From: Amanda Scholes on behalf of Planning.Responses
Sent: 17 March 2021 14:10
To: Planning Scanning
Subject: FW: Planning Consultation on: CM/11/21/DOC

Application No: CM/11/21/DOC

Site Address: Scyld Horsemere Green Lane Climping BN17 5QZ

Description of Works: Approval of details reserved by condition imposed under CM/21/19/PL relating to conditions 11-surface water drainage scheme, 12-discharge of flows to water courses or for the culverting, diversion, infilling or obstruction of any water course on or adjacent to site & 13-maintenance and management of surface water drainage system.

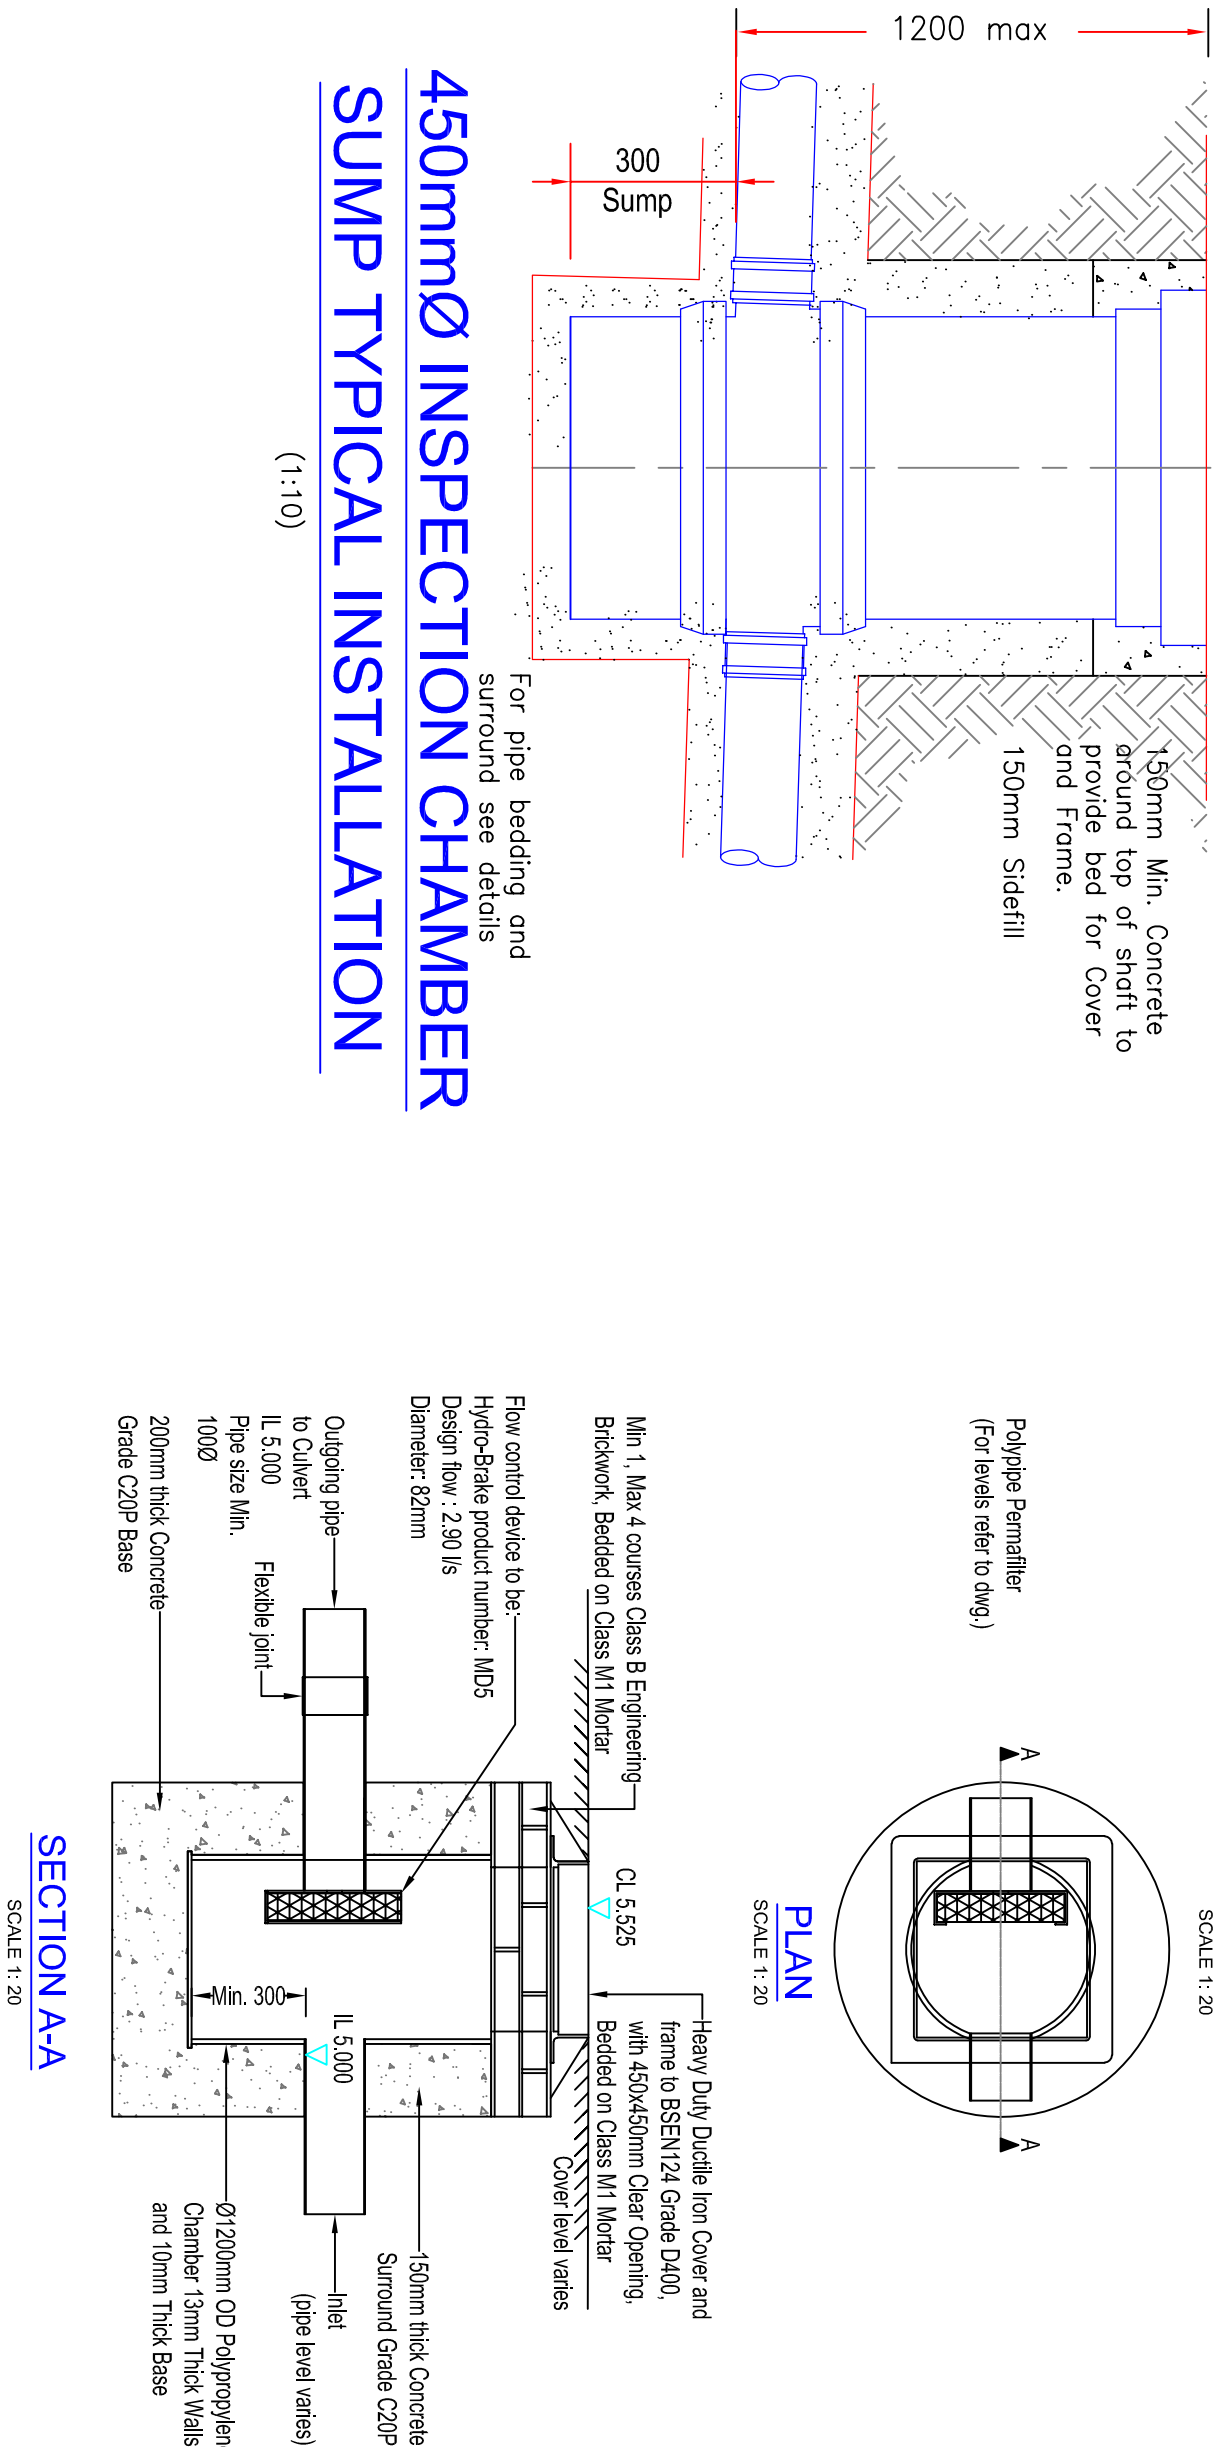
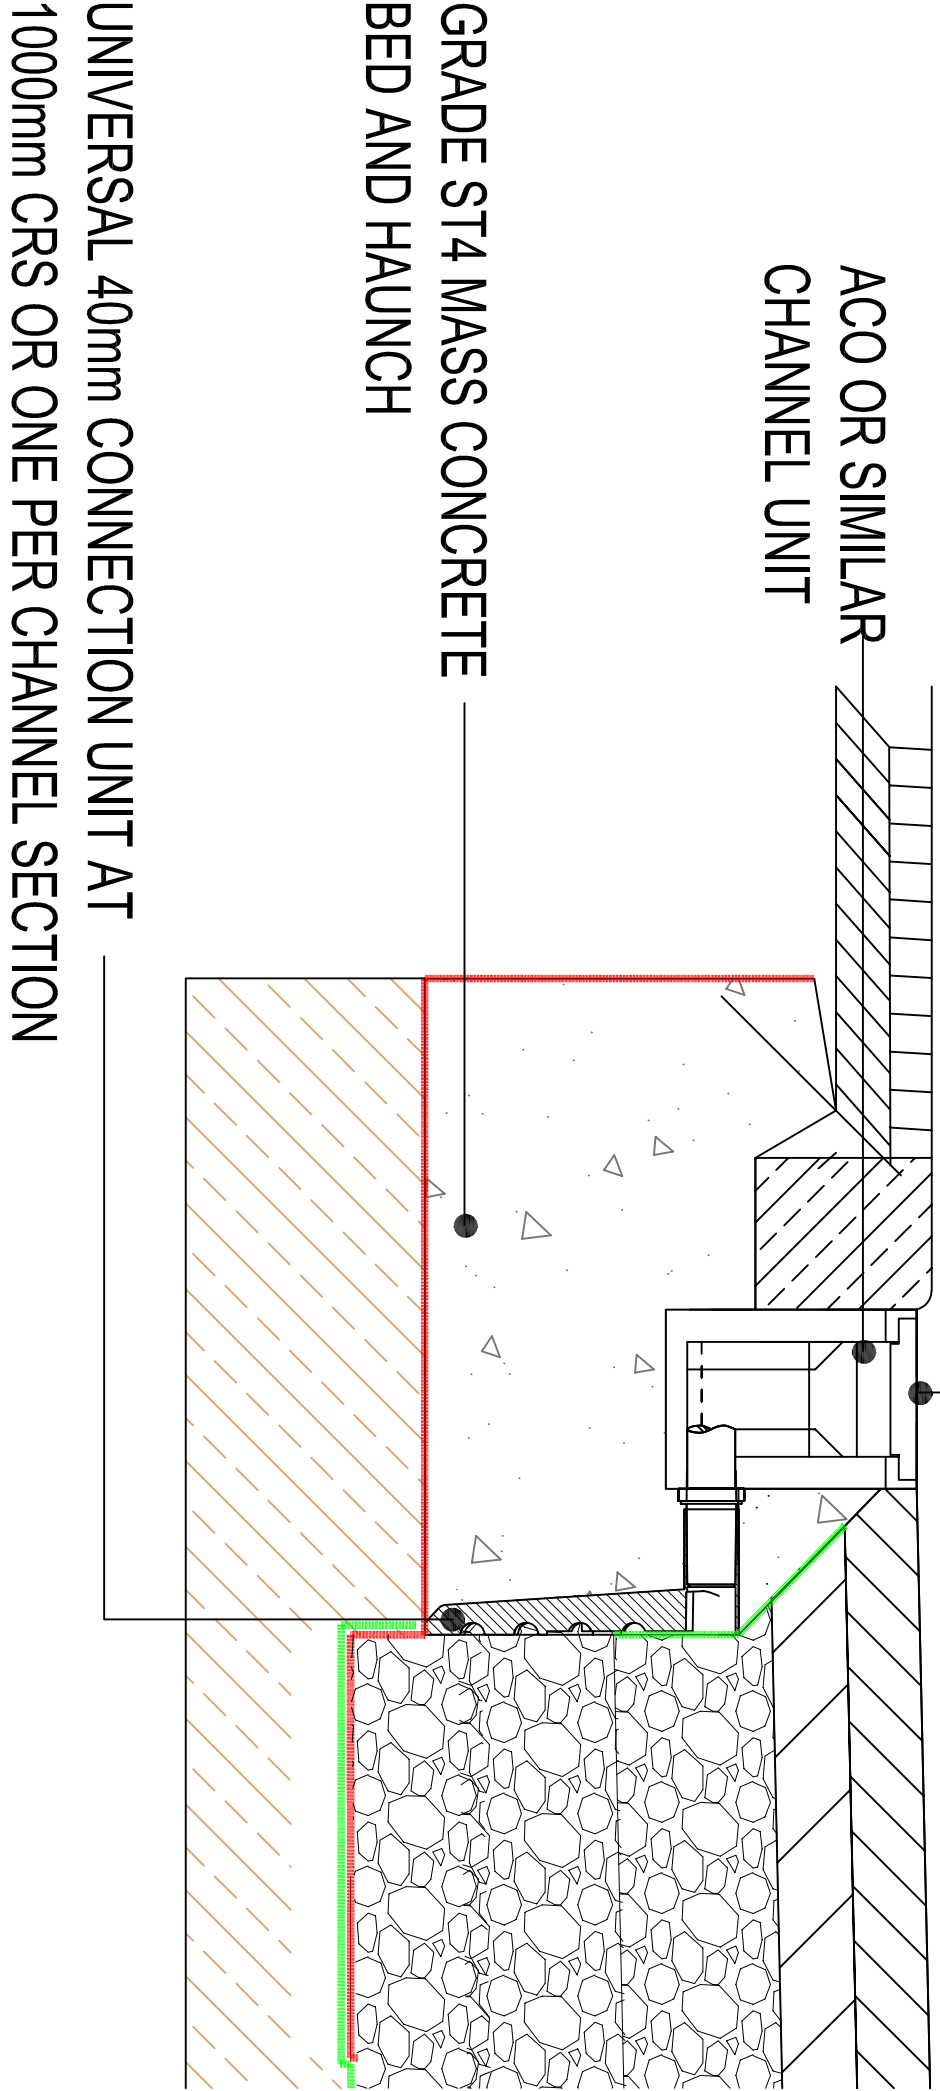
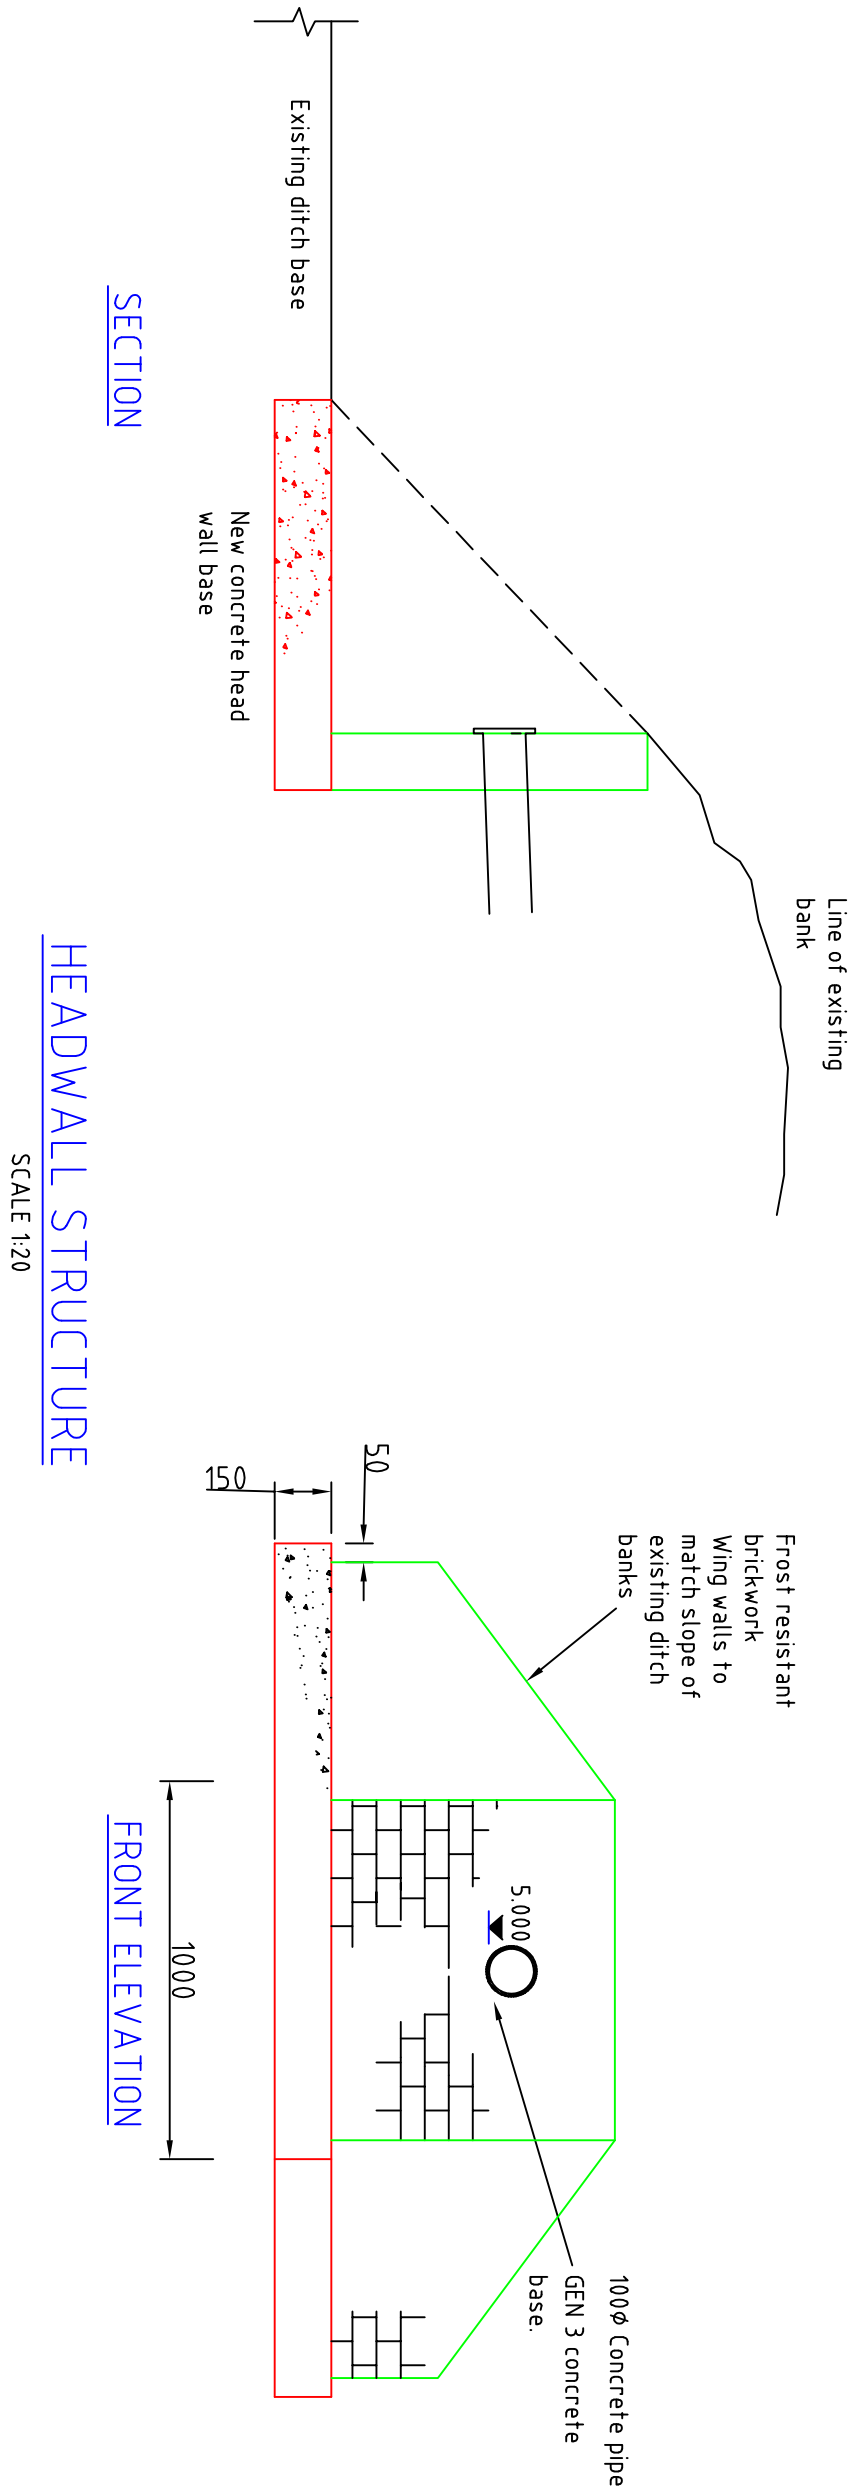
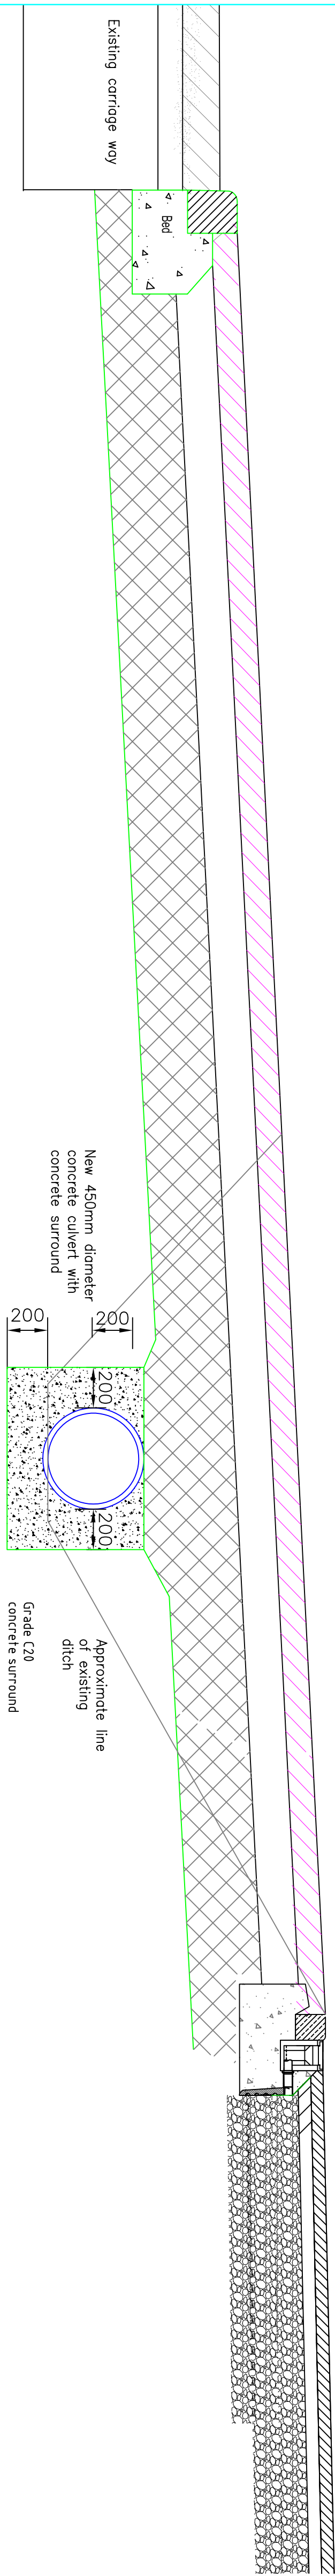
3. The long section on the drainage details sheet 1 refers to a hydrobrake with a restriction of 2.0l/s, which conflicts with the calculations, other details and layout (although addressing point 1 will affect these).

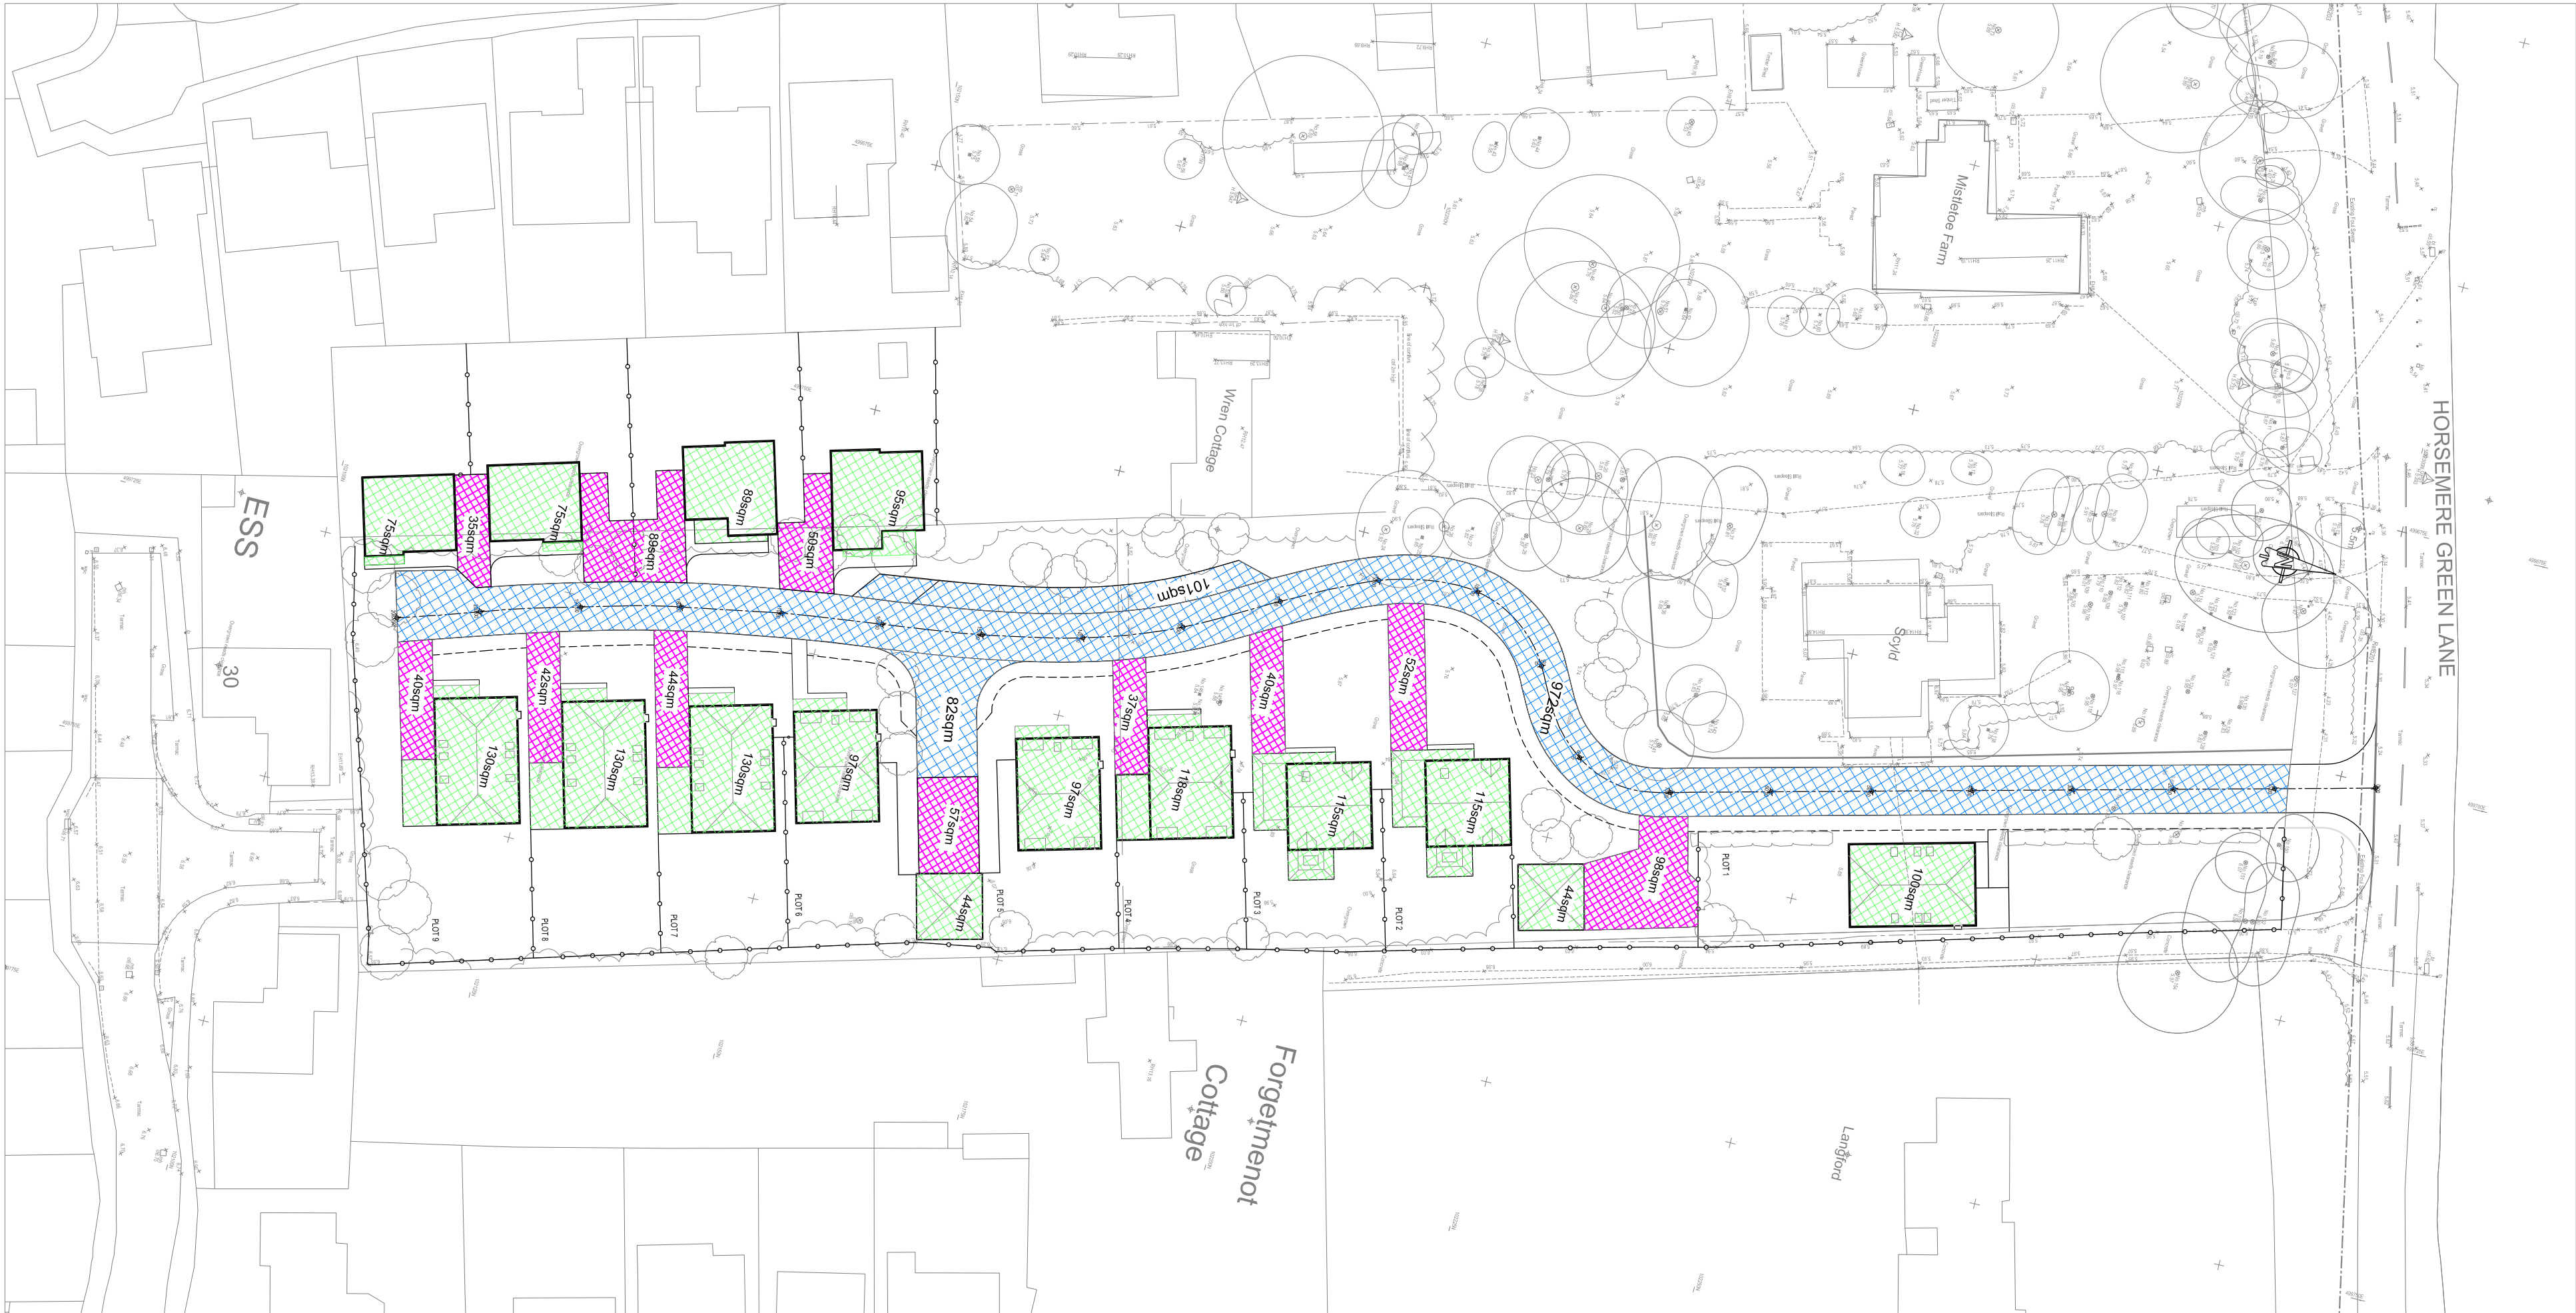
1. Greenfield runoff rates are based upon total site area rather than impermeable area that is draining to attenuation. Please restrict discharge to greenfield QBar for the area positively drained, or to 2l/s (whichever is greater).

2. The impermeable areas plan appears to use an old layout, not the latest layout as approved under CM/55/20/PL. Please provide an updated impermeable areas plan.
